**RE: MIXED USE DEVELOPMENT WITH AFFORDABLE HOUSING 160 OXFORD PADDINGTON
(SSD97528708)****INTRODUCTION**

This submission is an objection to the proposed mixed use development with affordable housing at No. 160 Oxford Street Paddington. This submission supports and endorses the submission by Paddington United objecting to the proposal.

East elevation Shadforth St & Victoria Barracks showing scale mis match with context, Design Report

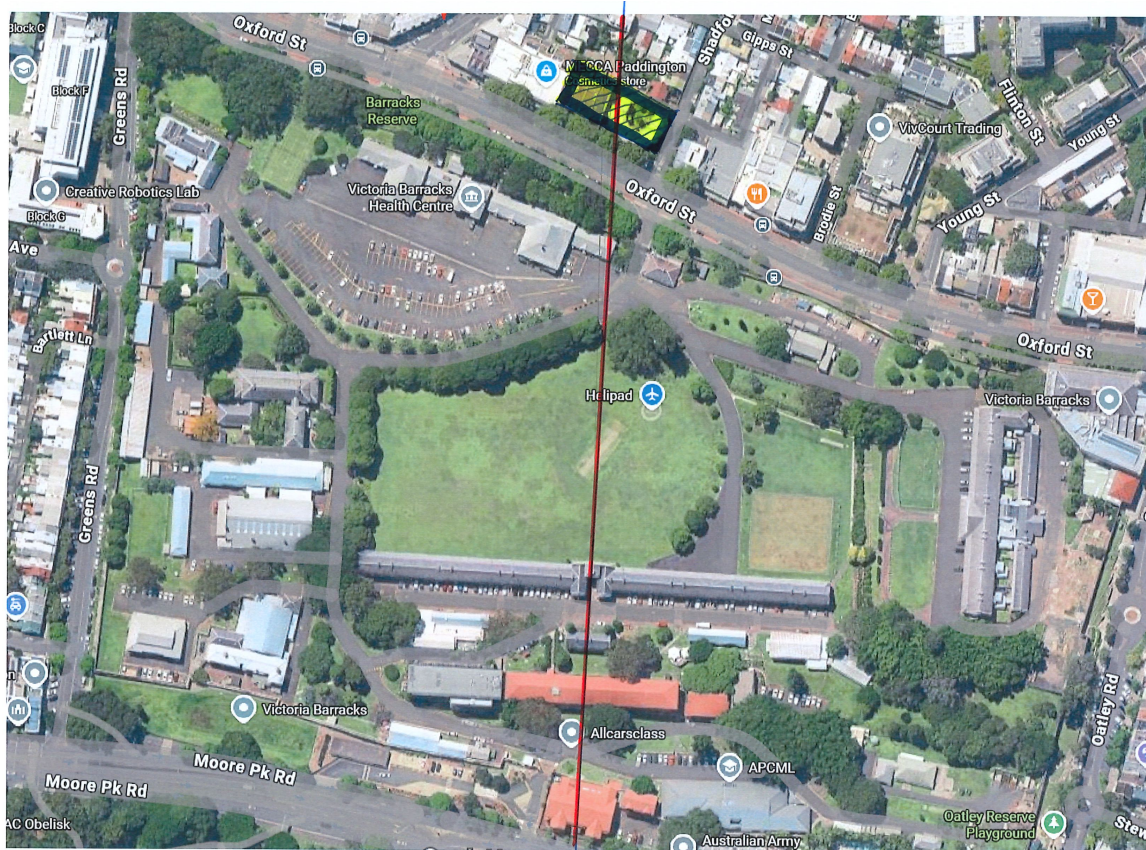
Eight stories plus rooftop does not repeat the scale of adjacent contributory single storey cottages and two storey terraces as shown in the architects eastern elevation reproduced below.

The proposed development does not satisfy the guidelines in the DCP for height and massing (building volume and size), as it is excessive in height, building volume and size. The building dominates the Conservation Area and is intrusive due to the scale. The proposal does not achieve the heritage provisions in the LEP to conserve environmental heritage

The eastern elevation of the proposed development. The green shading is the wall plane of the adjacent contributory buildings. The blue line is the characteristic ridge line. The red line is an eye height projection to the northern edge of the rear building roof of the building.
